**KIRKLEES METROPOLITAN COUNCIL
INVESTMENT & REGENERATION SERVICE**

**DELEGATED DECISION FOR DISCHARGE OF CONDITION -
NOTIFICATION OF A CHANGE OF USE UNDER THE ABOVE
PROVISIONS**

Reference no. 2024/CL/92809/E

Site Address	Popeley Farm, Muffit Lane, Gomersal, Cleckheaton, BD19 4QS
---------------------	---

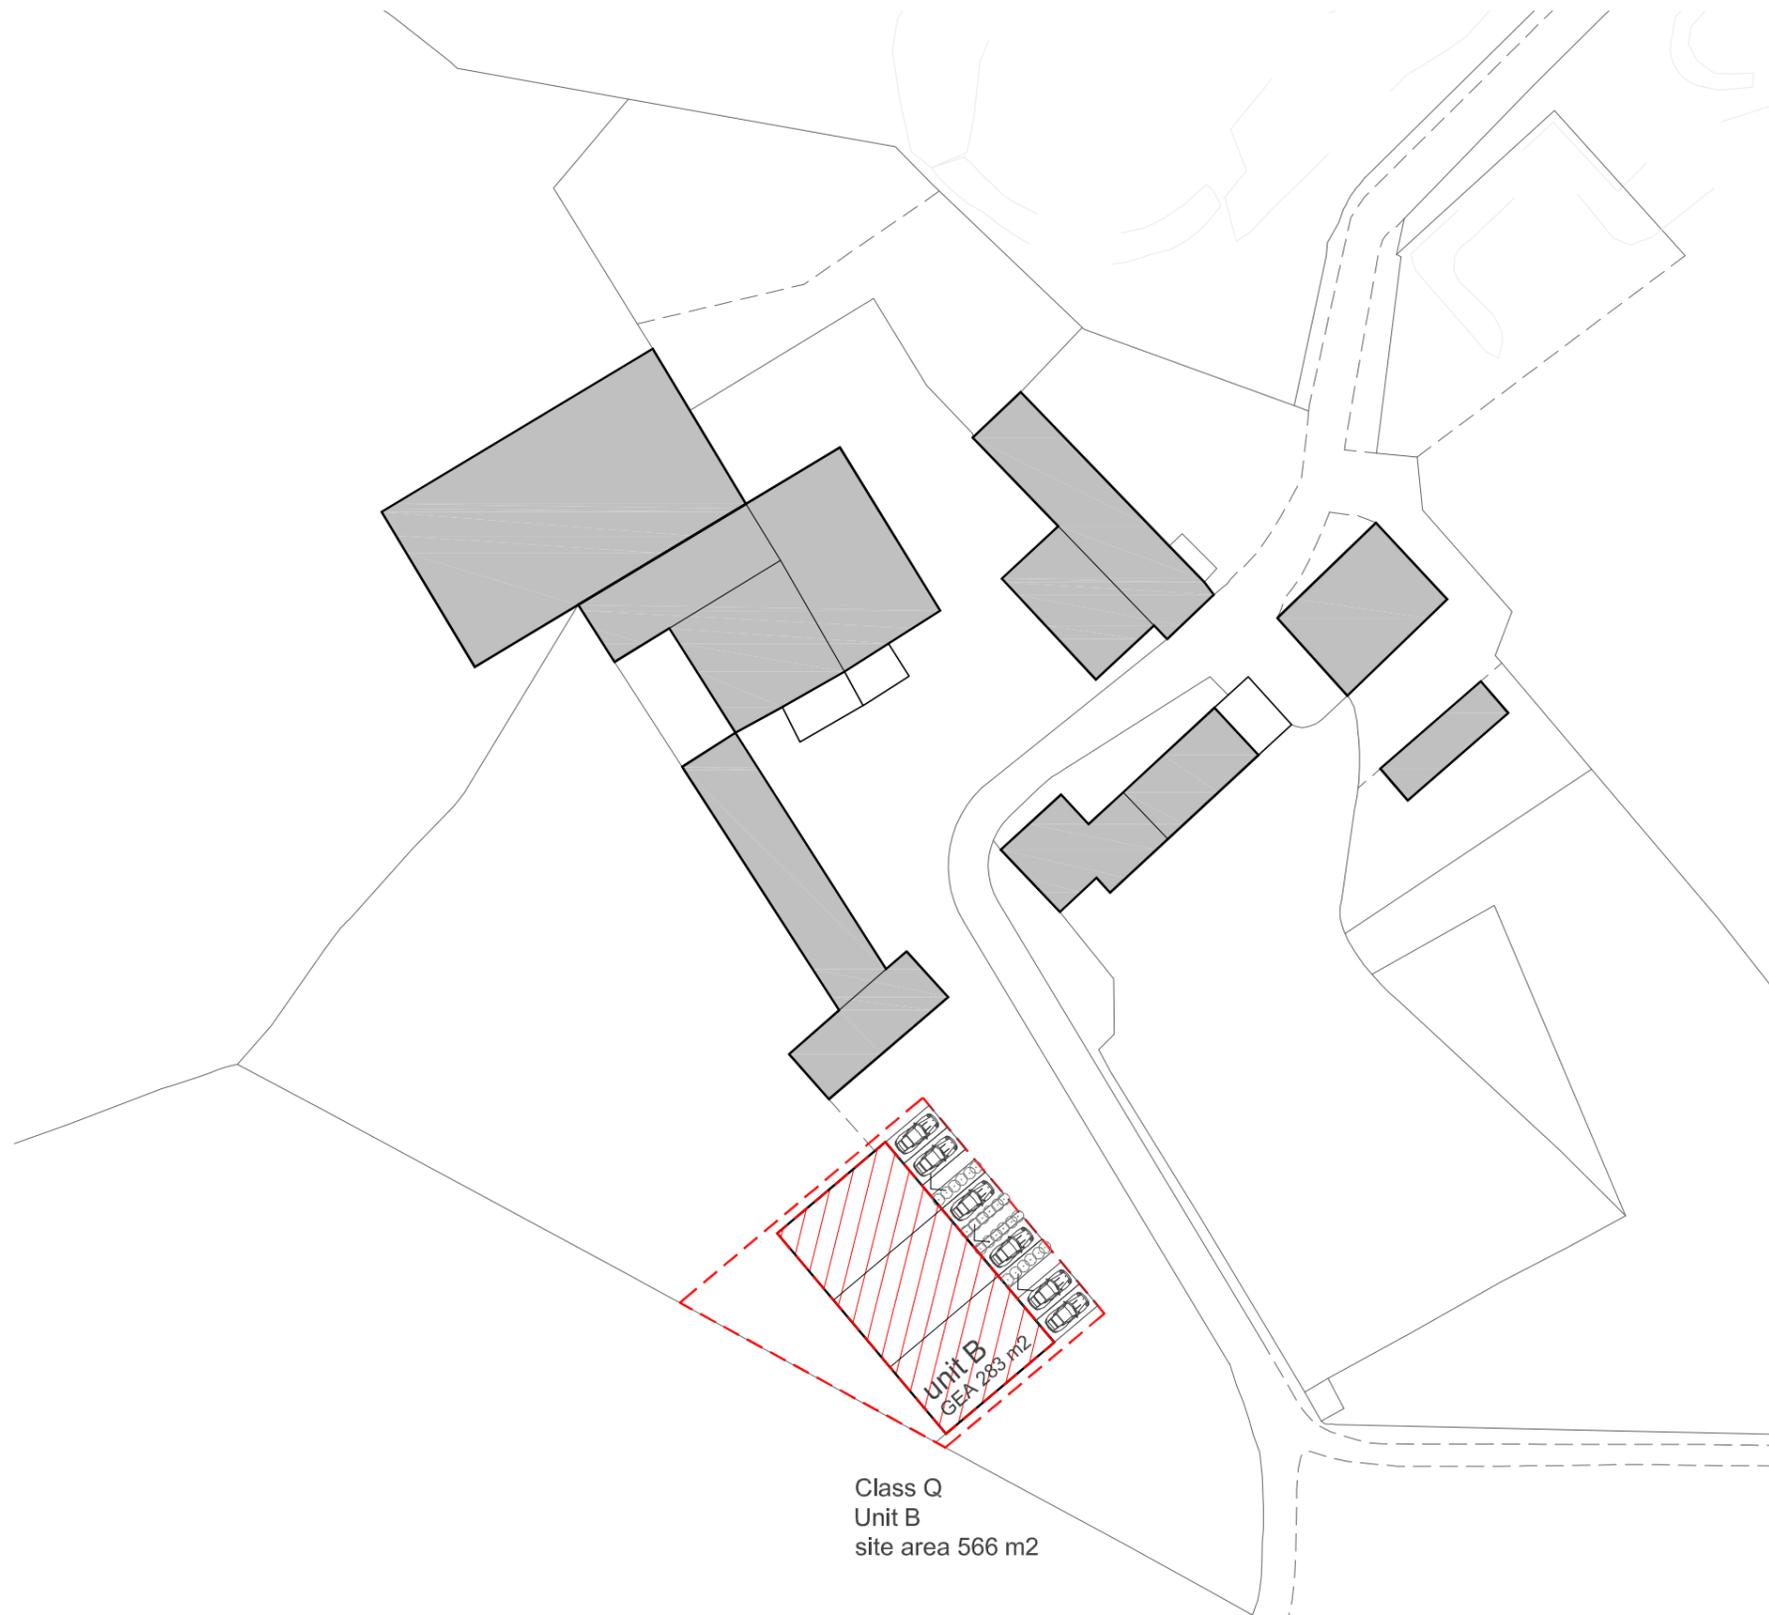
The curtilage identified to serve the development would be located immediately to the front and rear of the building and would not be larger than the land area occupied by the building. This is consistent with the definition of curtilage as prescribed in Part 3 of Class X.

Unit A east facing elevation as proposed scale 1 : 100 @ A3

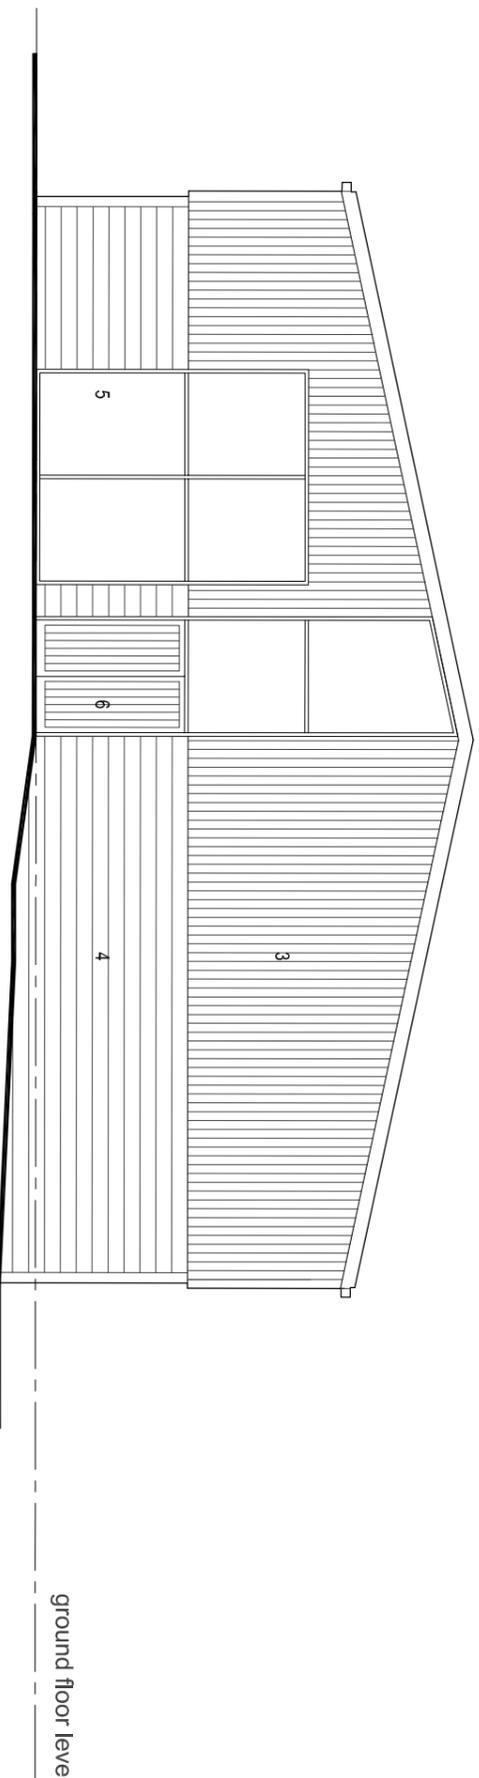
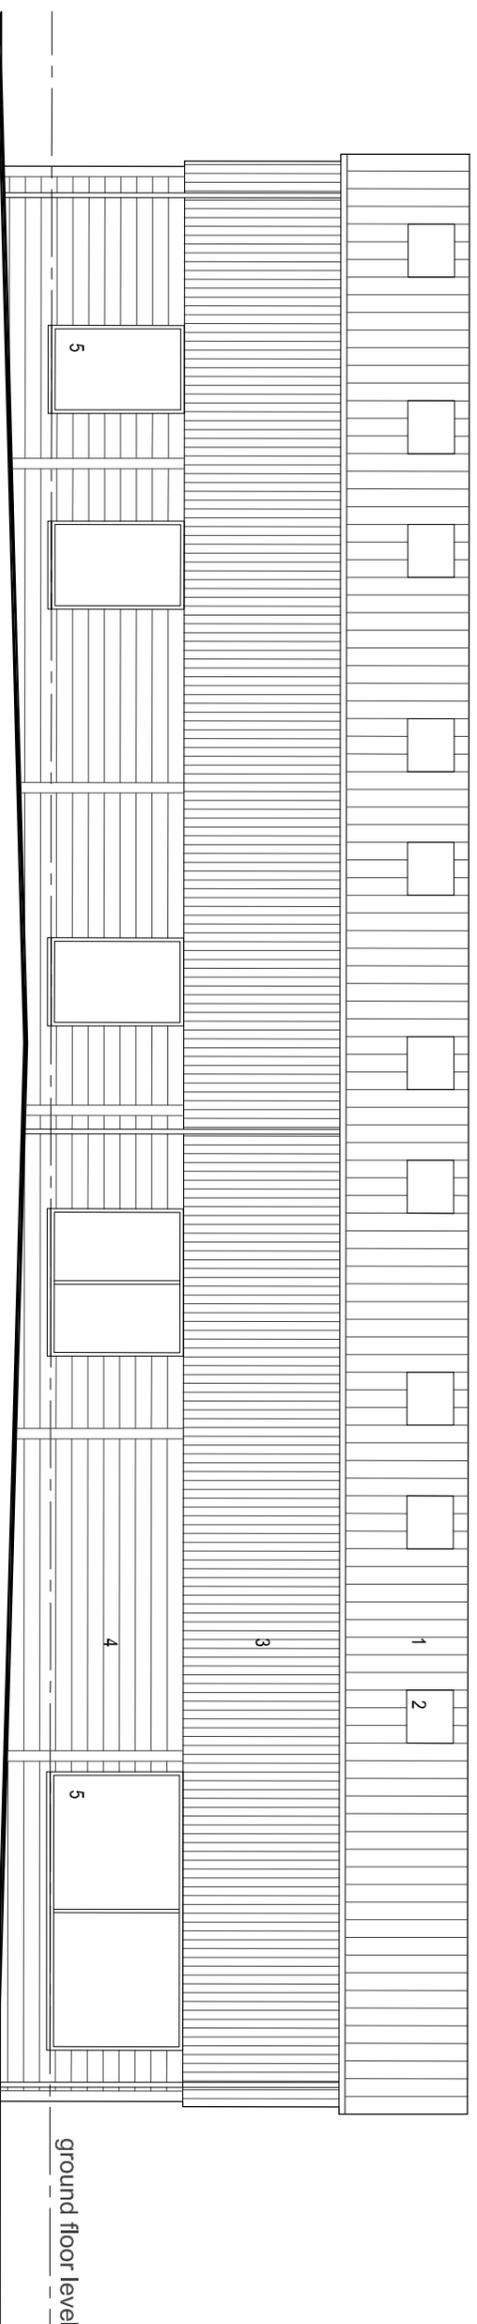
The design of the dwelling would be somewhat determined by the existing building, the form of which is to be mostly retained. The submitted plans confirm that the dwelling would be faced in fairfaced blockwork with dark grey paint finish on the lower sections, with vertical timber cladding to the upper walls. Furthermore, metal profiled sheets would be used for the roof. Although this material palette is not typical for the site and wider area, it is considered that the appearance of the proposed dwellings would be sympathetic to the original building and the surrounding rural character.

Unit A (B2) mezz floor plan scale 1 : 100 @ A3

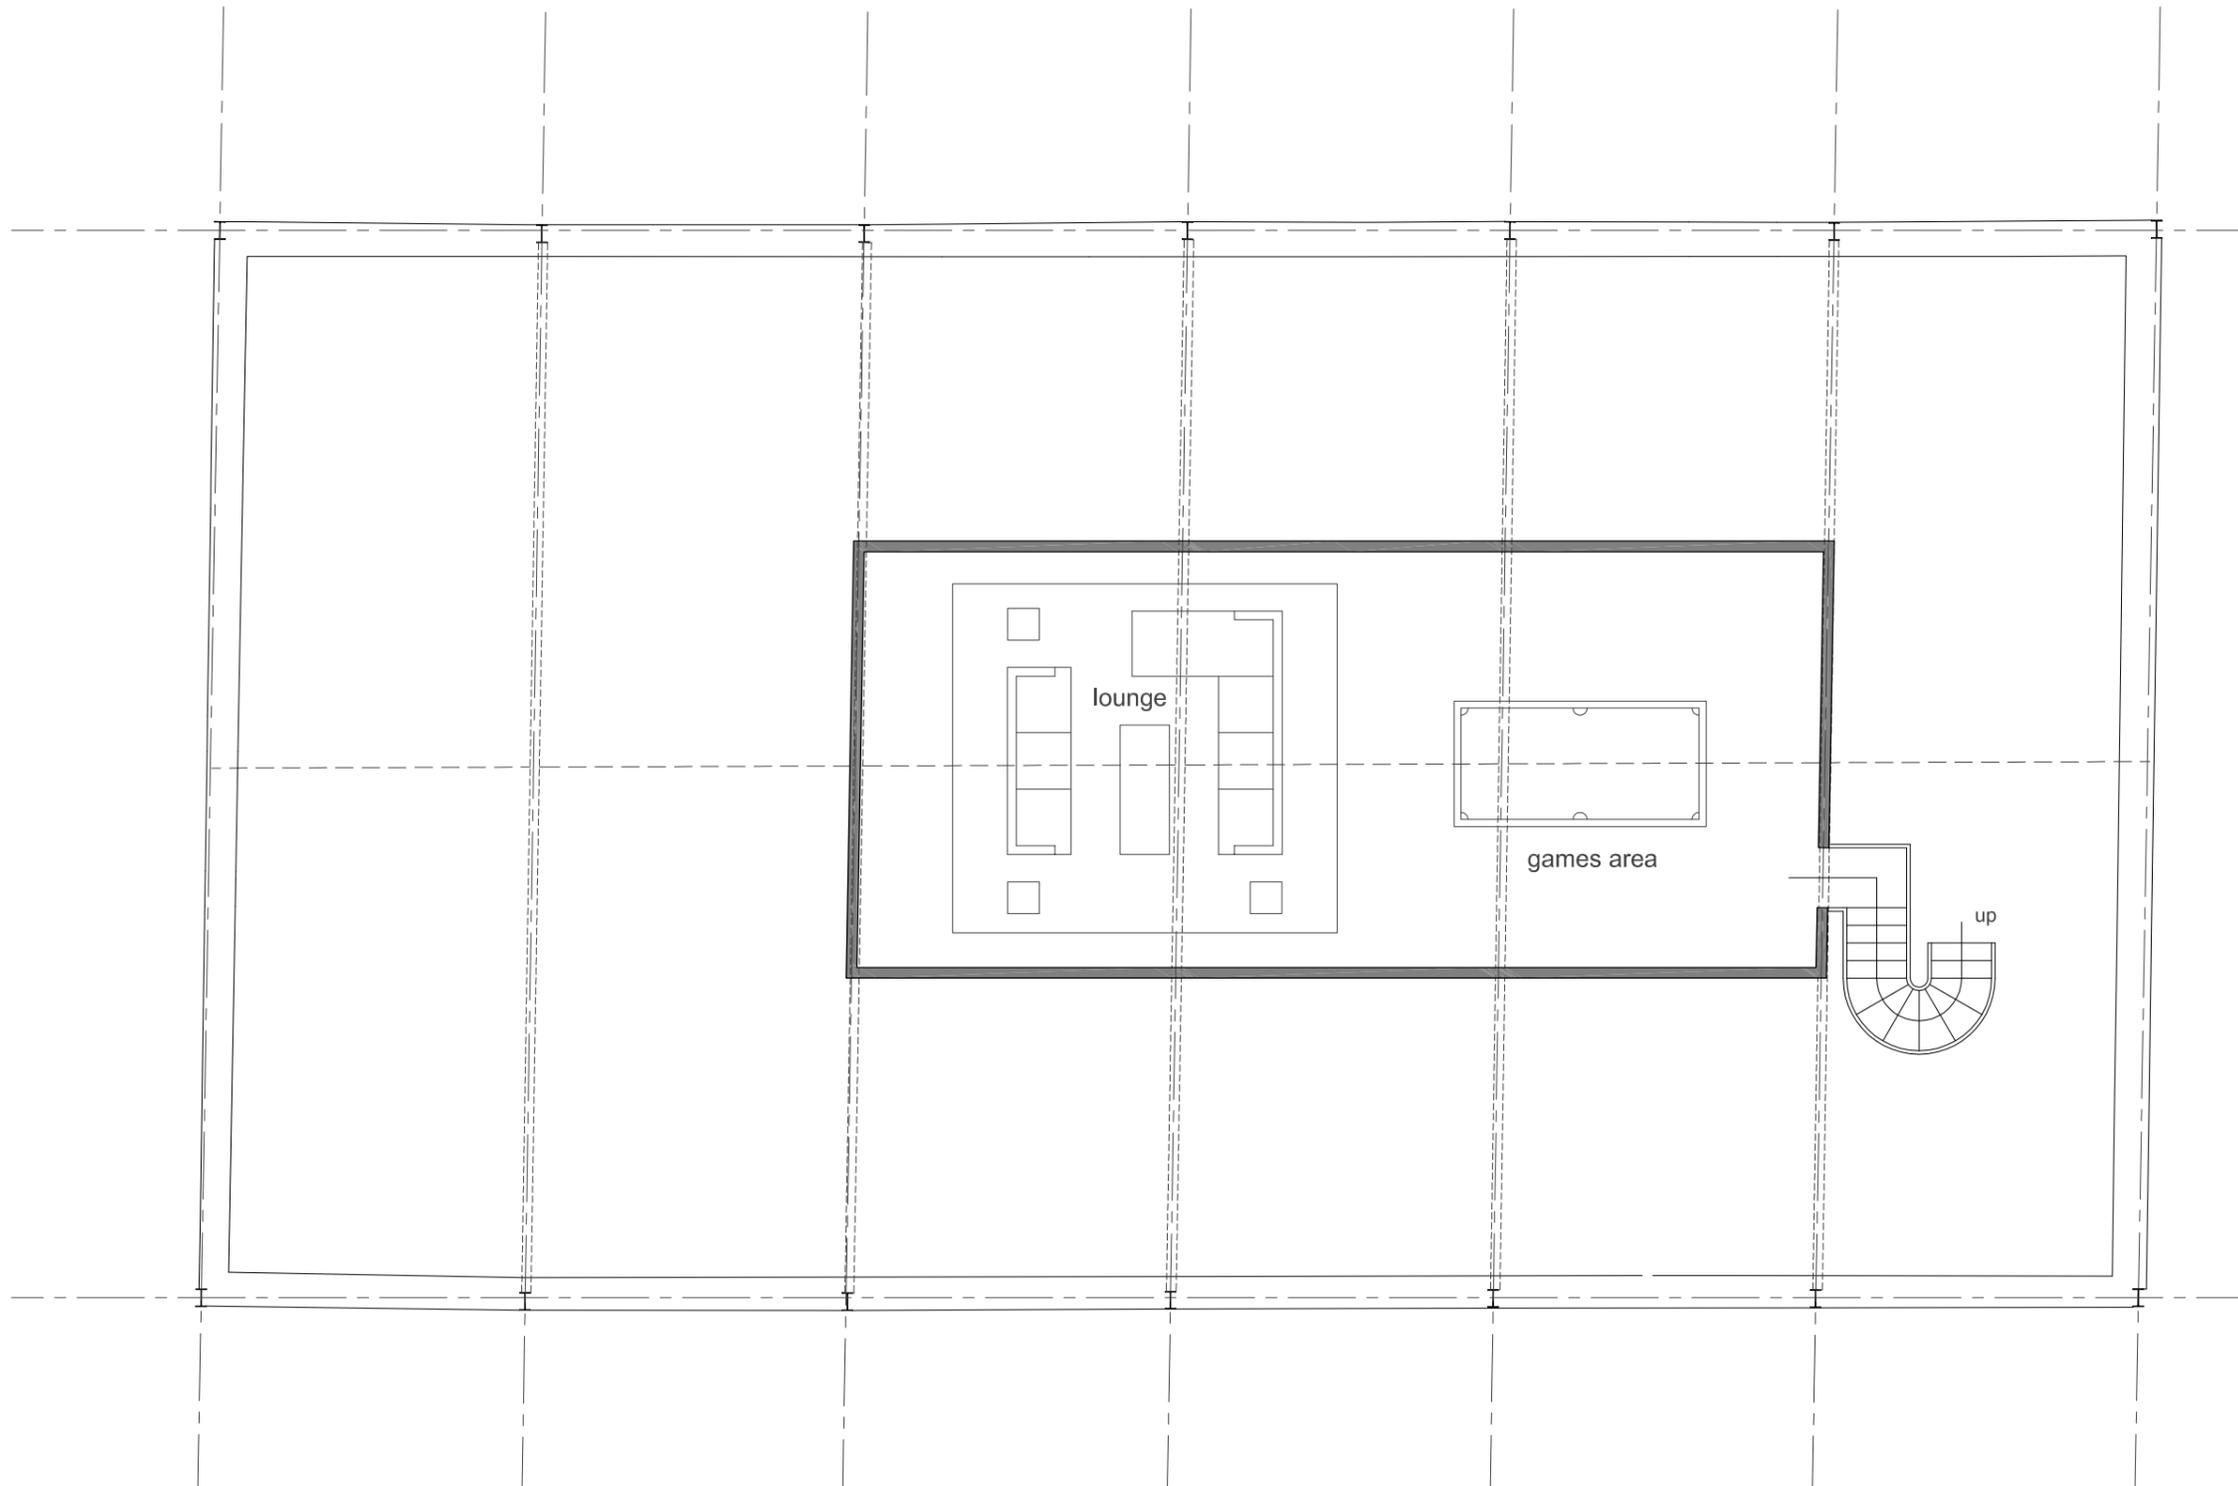
<p>the site has been used for any non-agricultural purpose</p>	
<p>(c) the floor space of any dwellinghouse developed under Class Q having a use falling within Class C3 (dwellinghouses) of Schedule 1 to the Use Classes Order exceeds 150 square metres,</p>	<p>Fail: The floor space exceeds 150 sq metres.</p>
<p>(d) the development under Class Q (together with any previous development under Class Q) within the original limits of an established agricultural unit would result in -</p> <ul style="list-style-type: none"> (i) the cumulative number of separate dwellinghouses having a use falling within Class C3 (dwellinghouses) of Schedule 1 to the Use Classes Order exceeding 10, or (i) the cumulative floor space of dwellinghouses having a use falling within Class C3 (dwellinghouses) of Schedule 1 to the Use Classes Order exceeding 1,000 square metres, 	<p>Pass: The number of dwellings does not exceed 10 or 1000 square metres.</p>

The proposed floor plans show that dwelling would have four bed spaces and is shown to have an internal floor space of 463m². It is also noted that each of the habitable rooms would benefit from a sufficient amount of natural light. Furthermore, off road parking would also be provided on site and the dwelling would benefit from a sufficiently sized outdoor amenity space.

The proposed development is not considered to benefit from a general planning permission under Article 3(1) and Class Q, Part 3 of Schedule 2 of the Town and Country Planning (General Permitted Development)(England) Order 2015 (as amended) as the floor space exceeds 150 square metres contrary to subparagraph Q.1(c) of Class Q.
